WEST SUSSEX COUNTY COUNCIL CONSULTATION

TO:	Arun District Council FAO: Simon Davis
FROM:	WSCC - Highways Authority
DATE:	25 January 2022
LOCATION:	Land North of Lee's Yard Lidsey Road Woodgate PO20 3SU
SUBJECT:	AL/141/21/RES Approval of reserved matters following outline planning permission AL/21/20/OUT for the approval of the appearance, layout, scale and landscaping for 5 No 4-bed dwellings, 14 No 3-bed dwellings & 19 No 2-bed dwellings. This site is in CIL Zone 3 and is CIL Liable as new dwellings.
DATE OF SITE VISIT:	n/a
RECOMMENDATION:	No Objection
S106 CONTRIBUTION TOTAL:	n/a

Drawing Status		Final	
Client			
Southern Home Ownership and Thakeham Partnerships Ltd			
Project		Lees Yard, Lidsey Road, Woodgate	
Drawing Title			
Access Overview and Visibility Splays			
Scale	Date	Drawn By	Checked
1:250	Nov 21	SMO	ALB
Drawing No.			Rev.
2021-6331-001			A

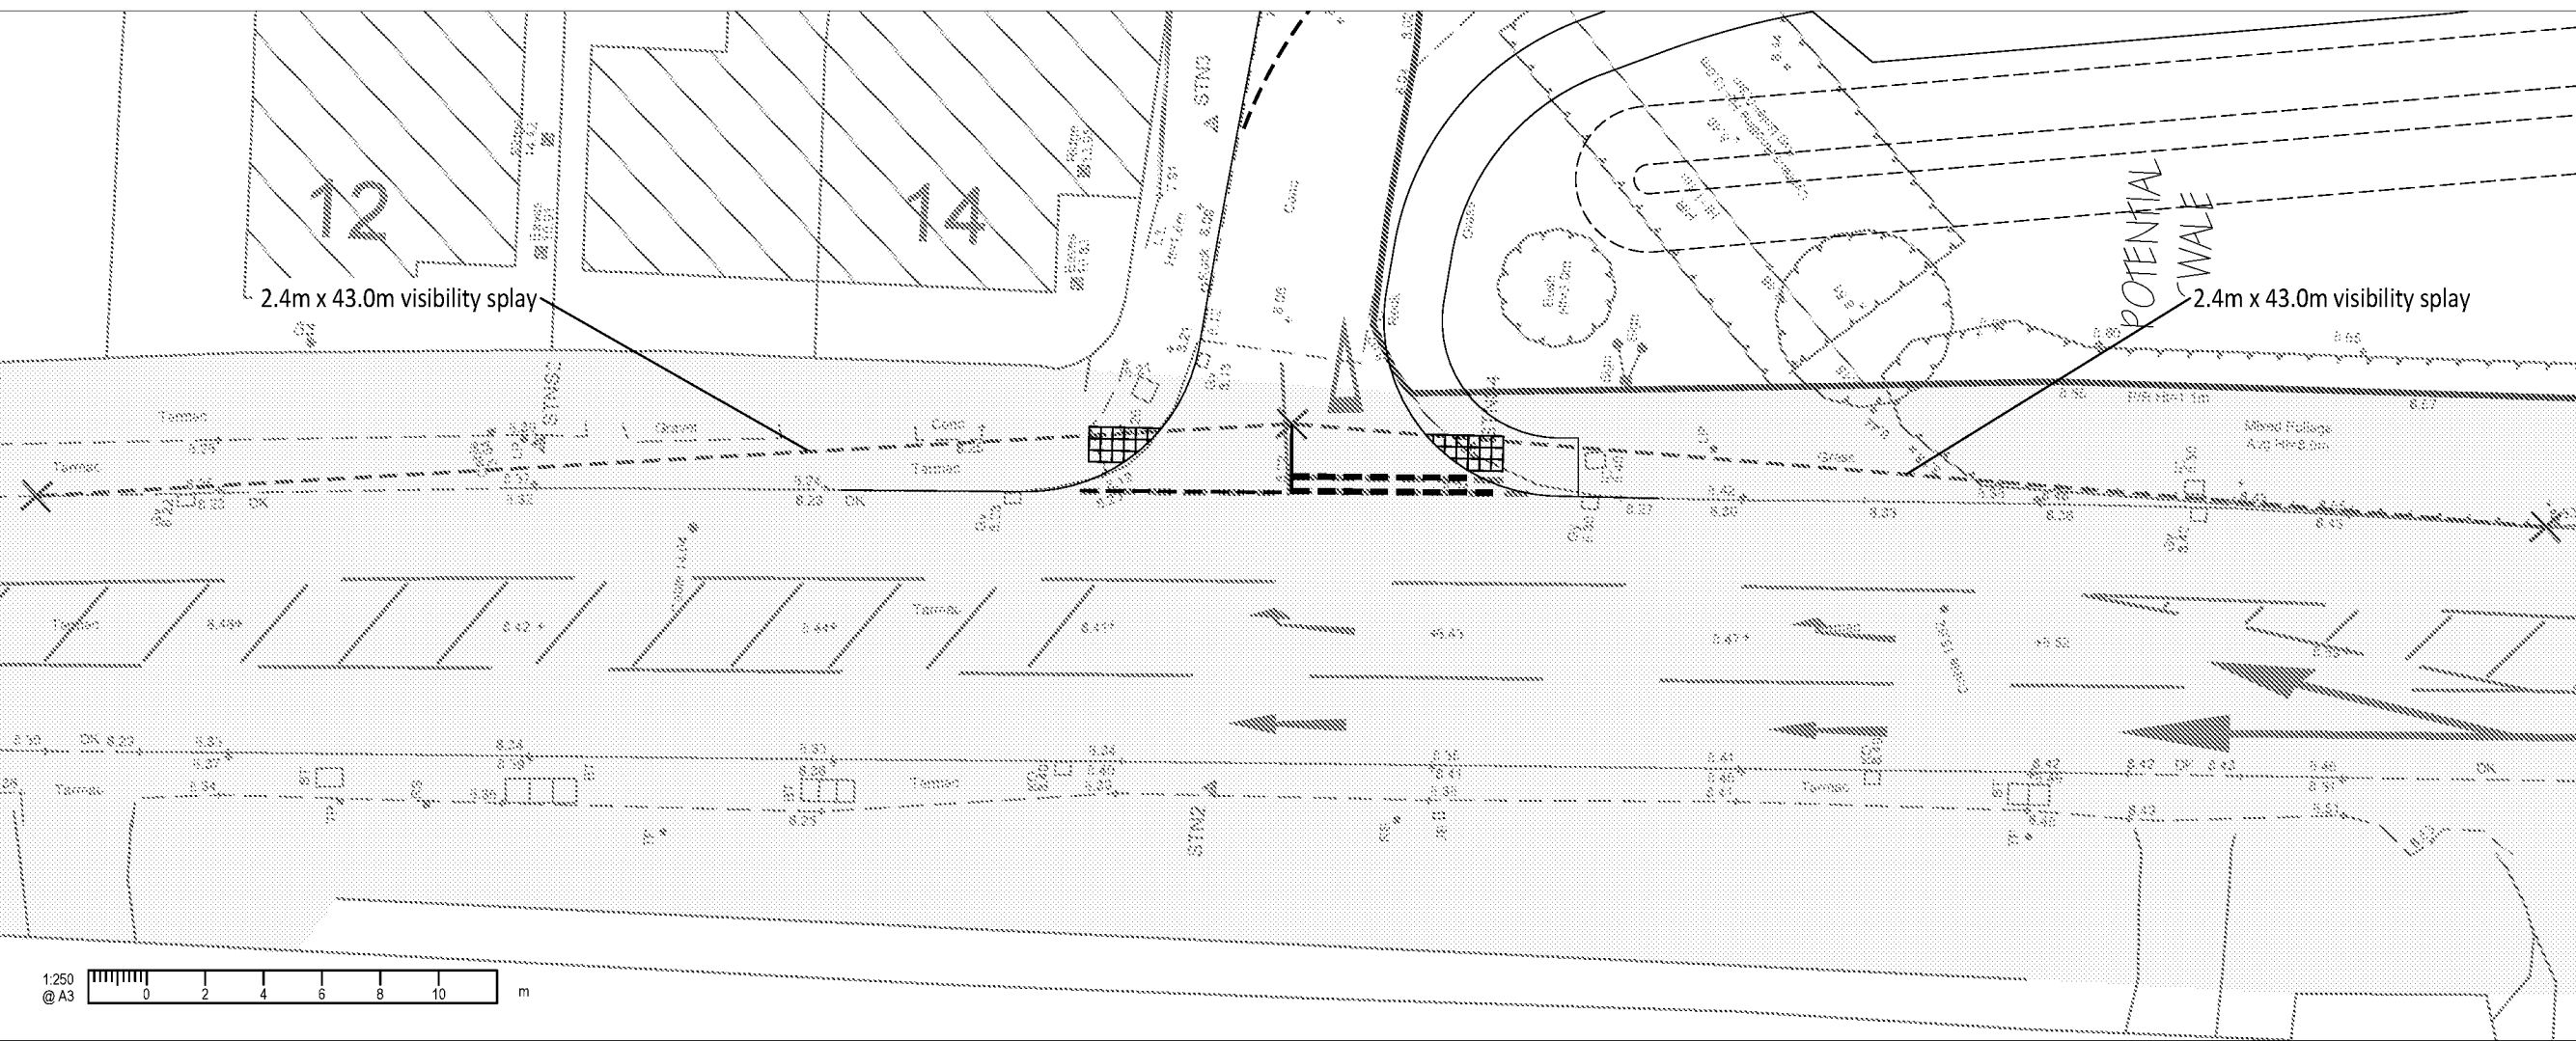
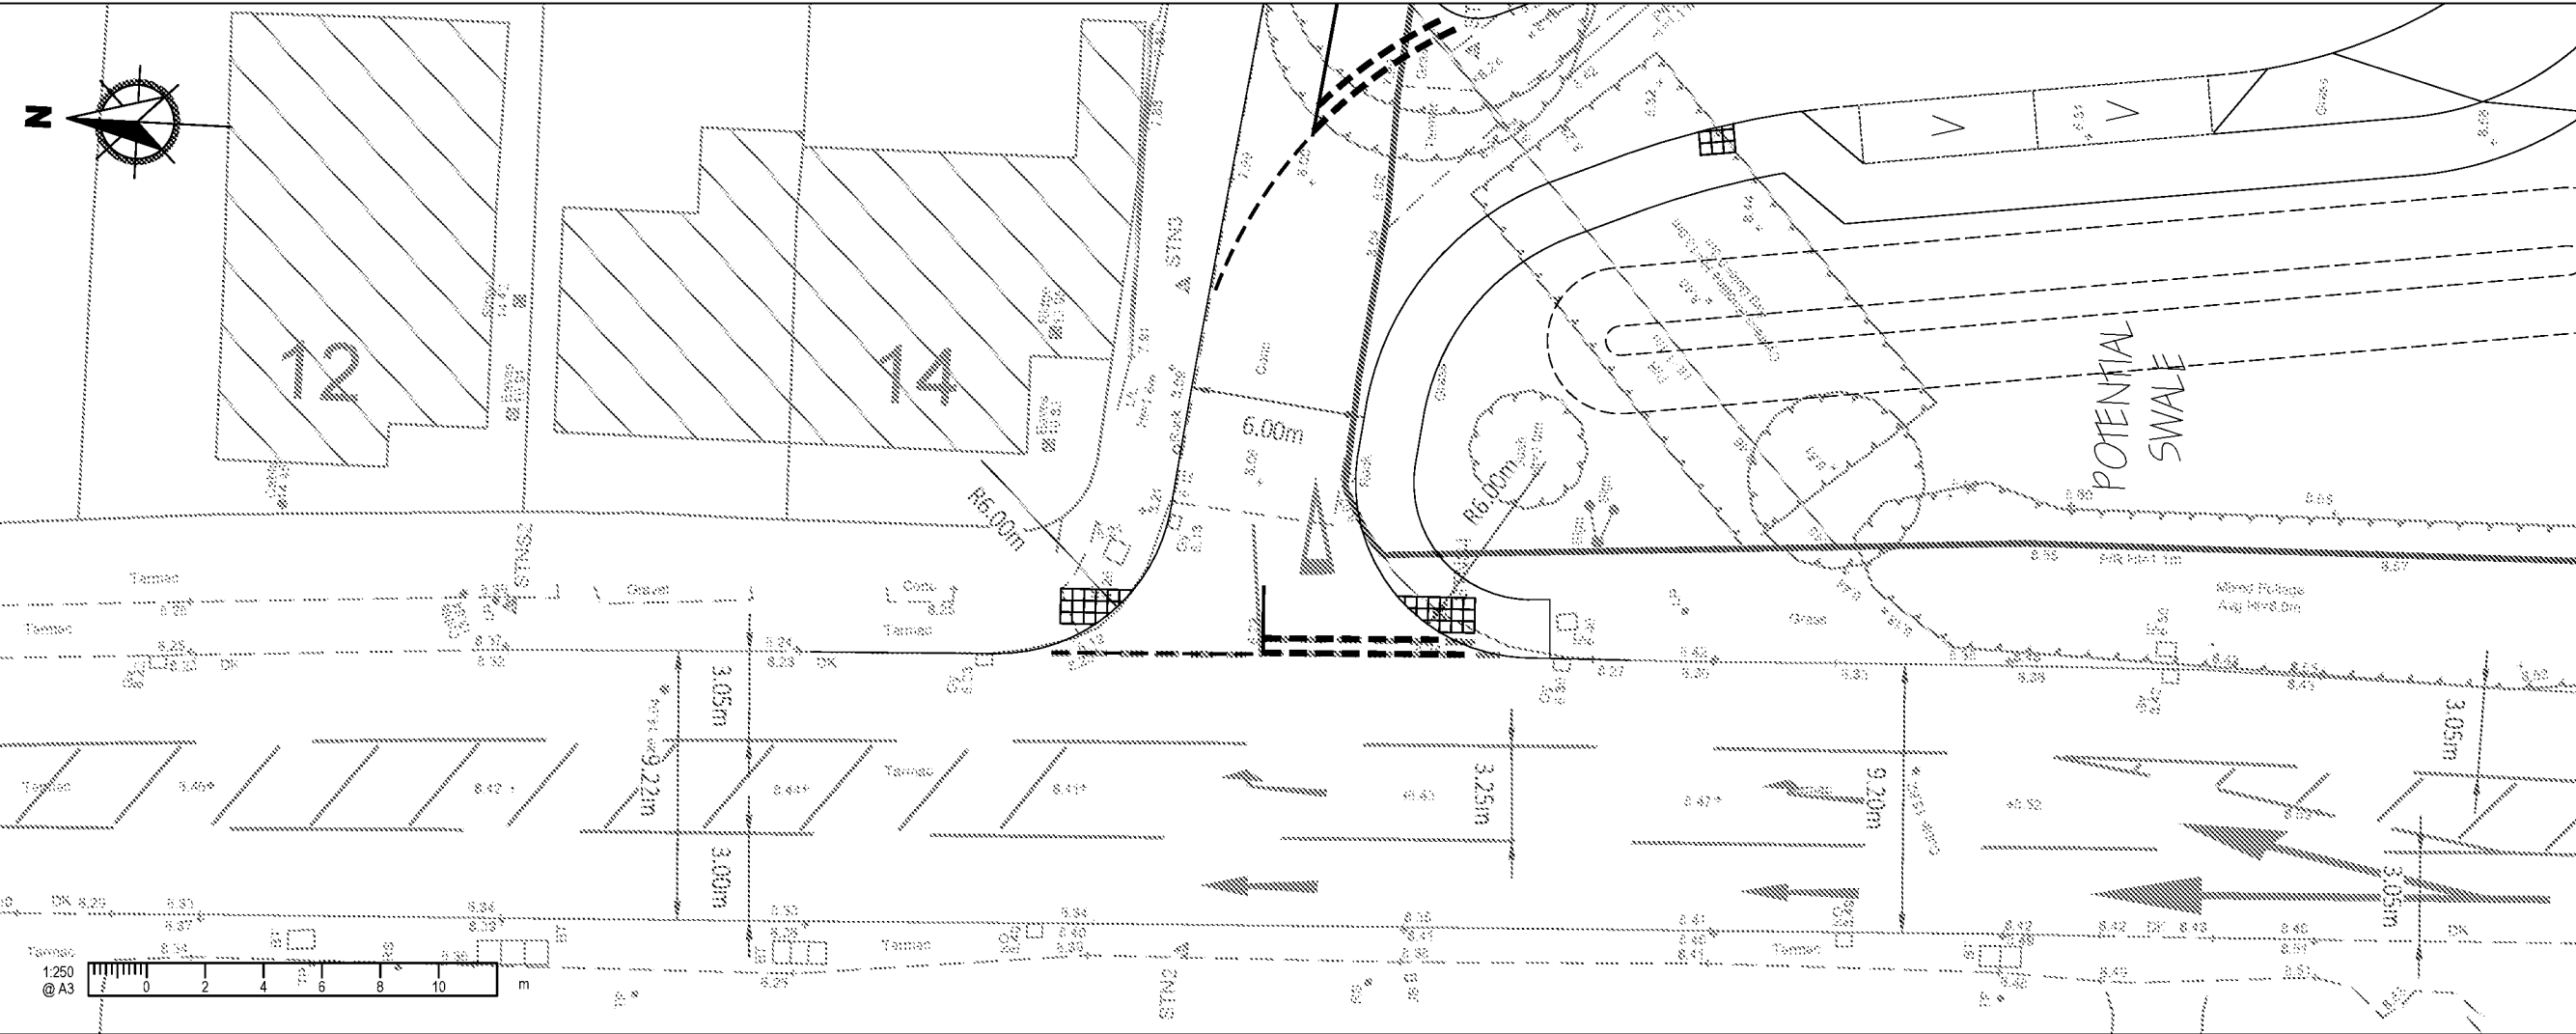
- The internal roads have been designed in accordance with Manual for Street parameters which the LHA accept in this context. Visibility splays of 2.4 by 25 metres have been demonstrated. The LHA would be satisfied with the splays given the likely internal speeds.
- Cycle Parking will be provided in secure and covered areas. The proposed cycle parking allocation is in line with ADC parameters.

APRIN DISTRICT COUNCIL ALU/141/21/RES

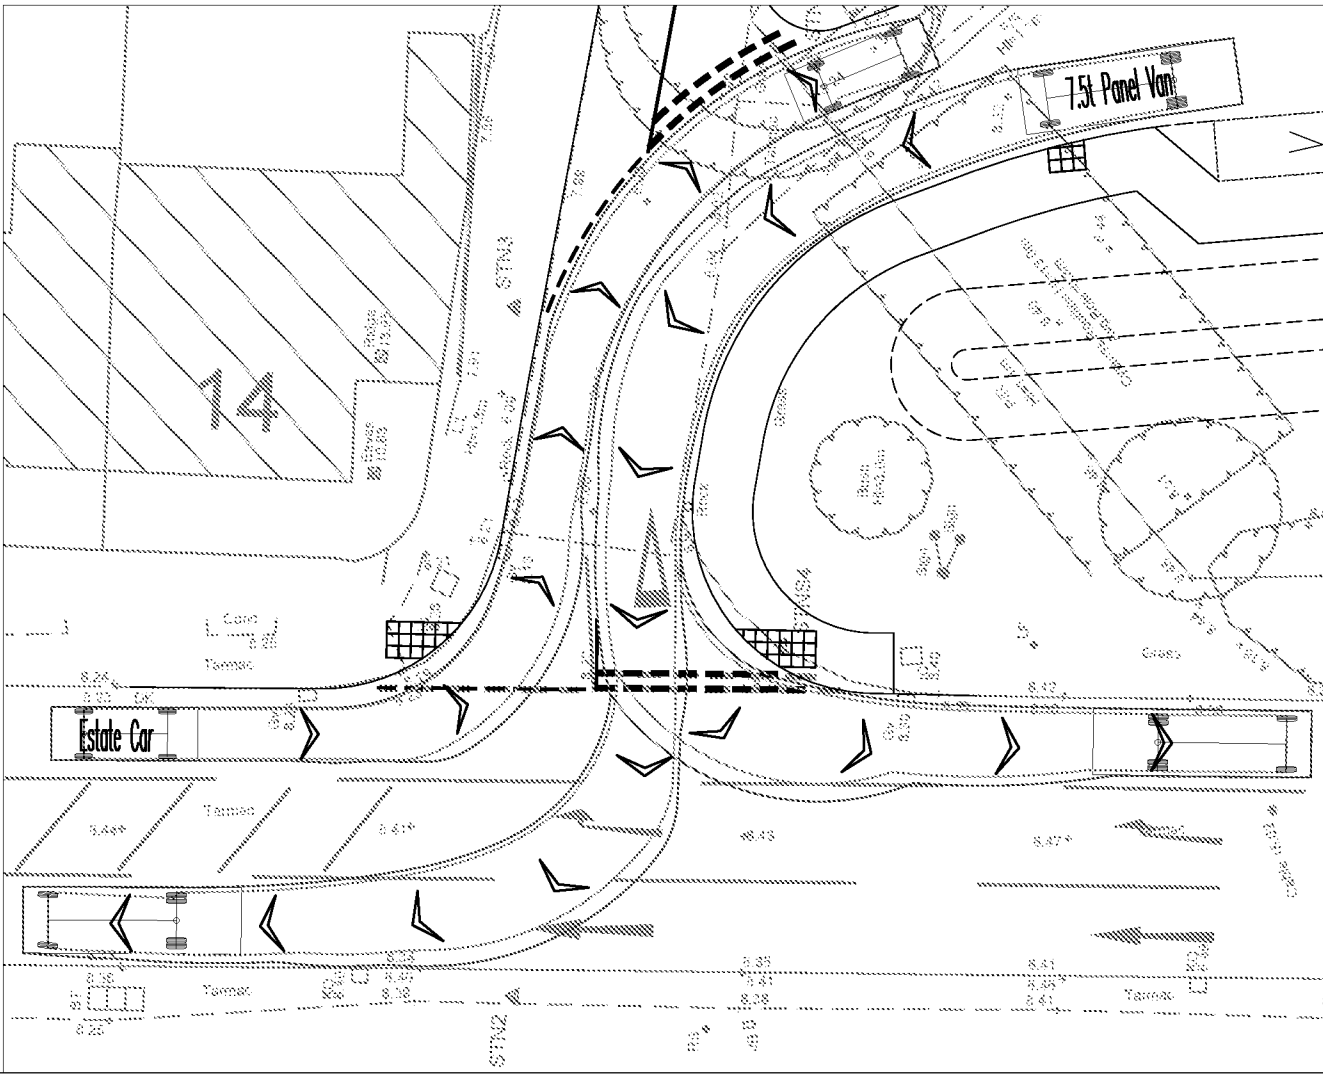
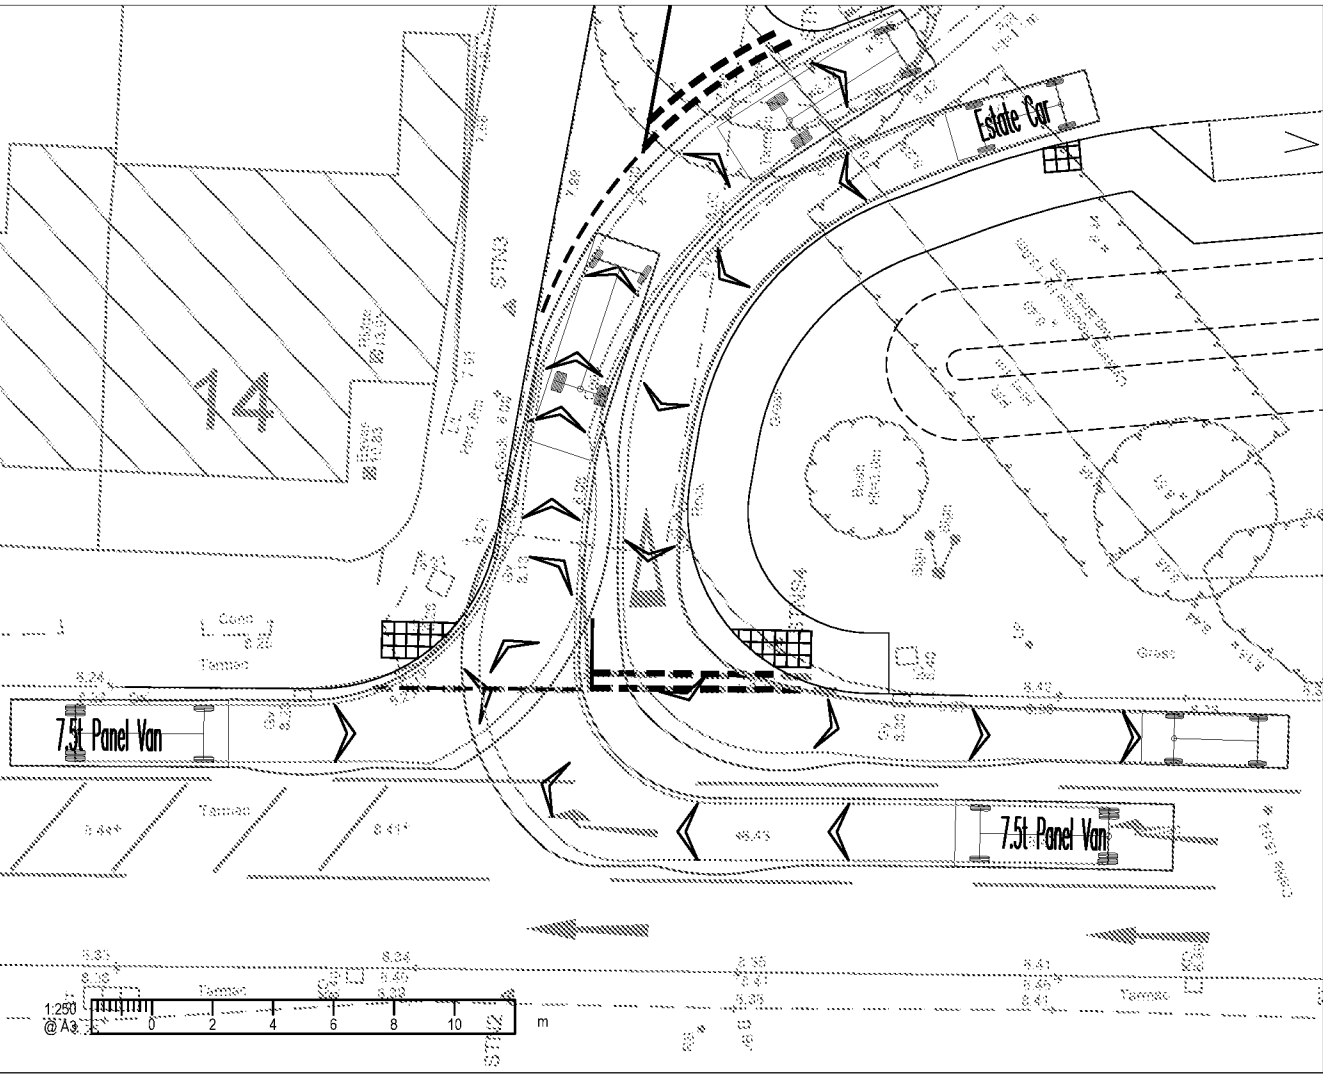
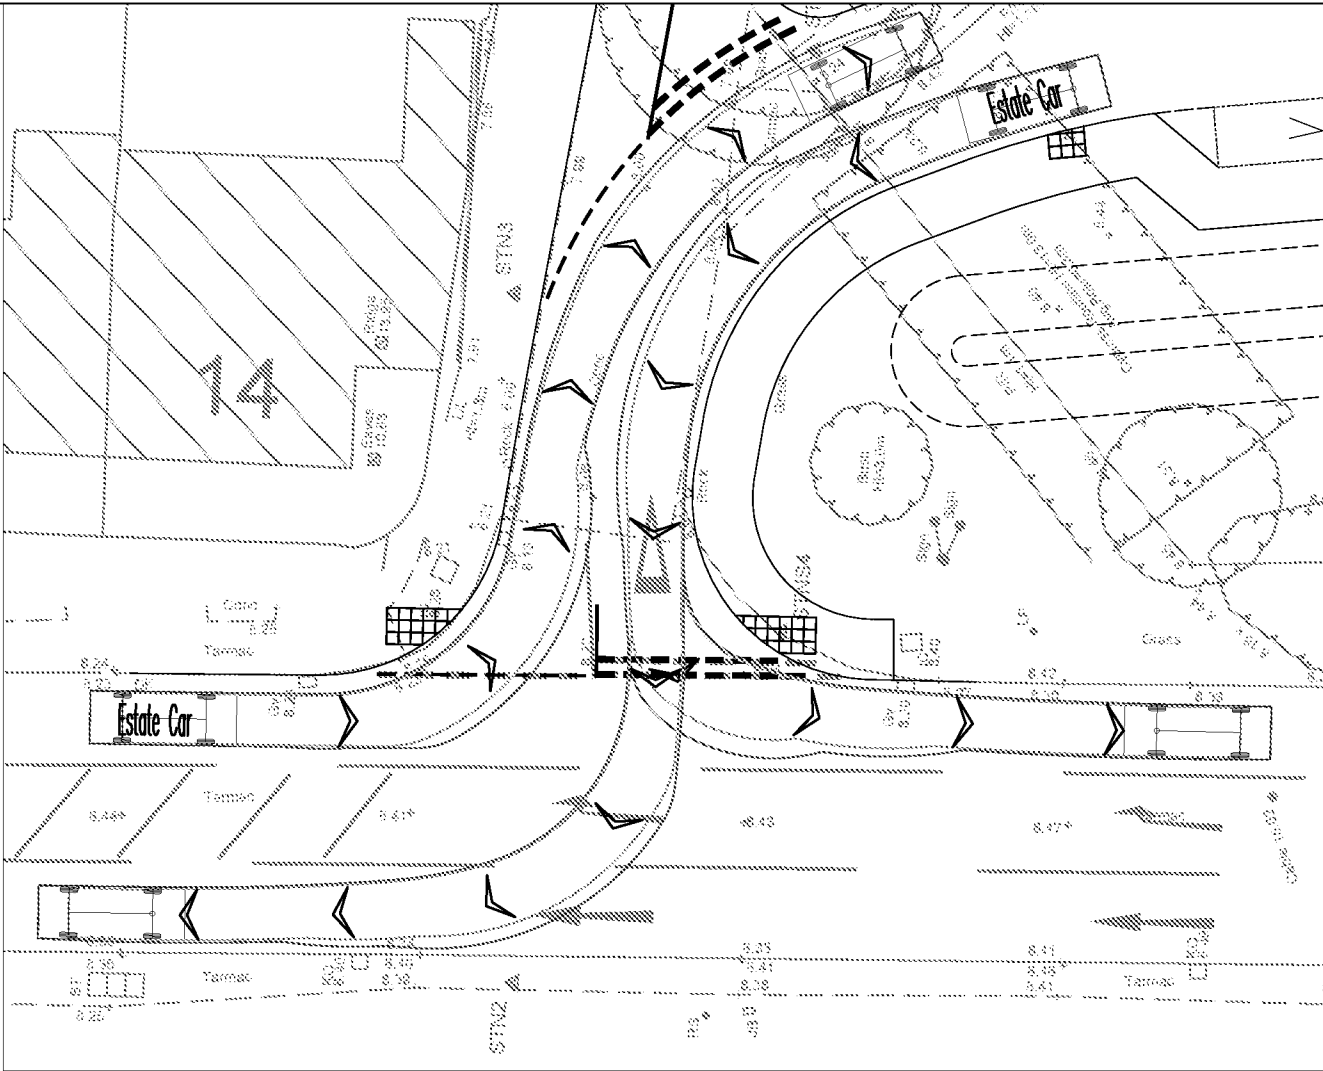
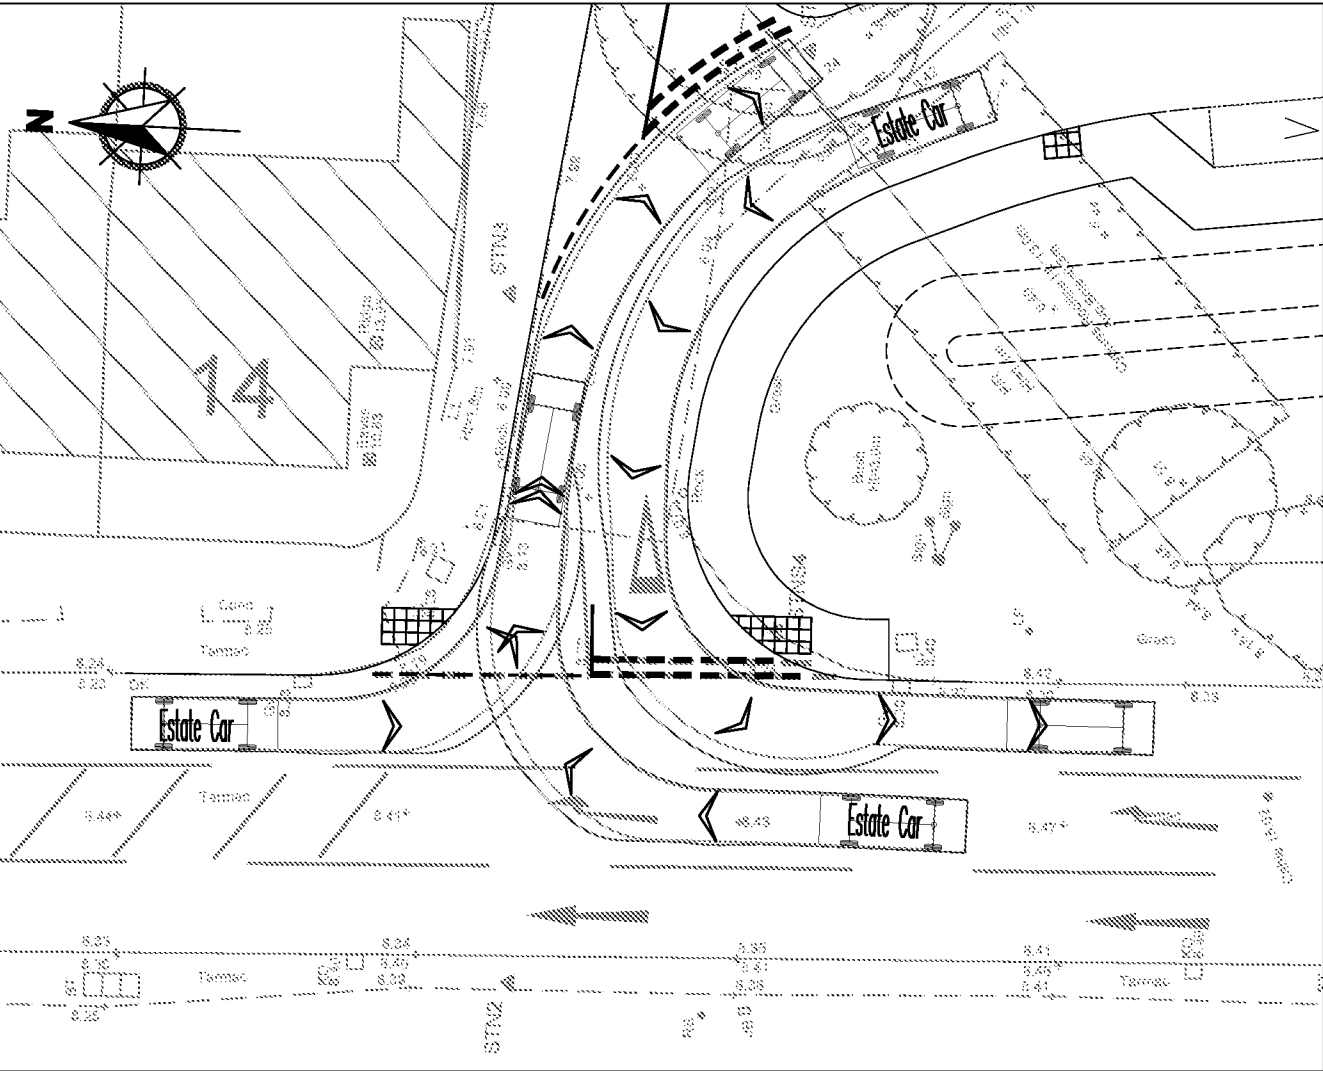
- The TS provides a number of Swept Path Analysis drawings. These include movements for a refuse tender, fire appliance and private cars.
- Trip Generation-this was considered in the LHA's response to the previous application AL/20/21. At this time no concerns were raised in relation to the number of additional movements onto the network. As a result of this application further trip calculations have been put forward. These are comparable to the earlier application, the LHA would still offer no objections to the number of vehicular movements to and from the
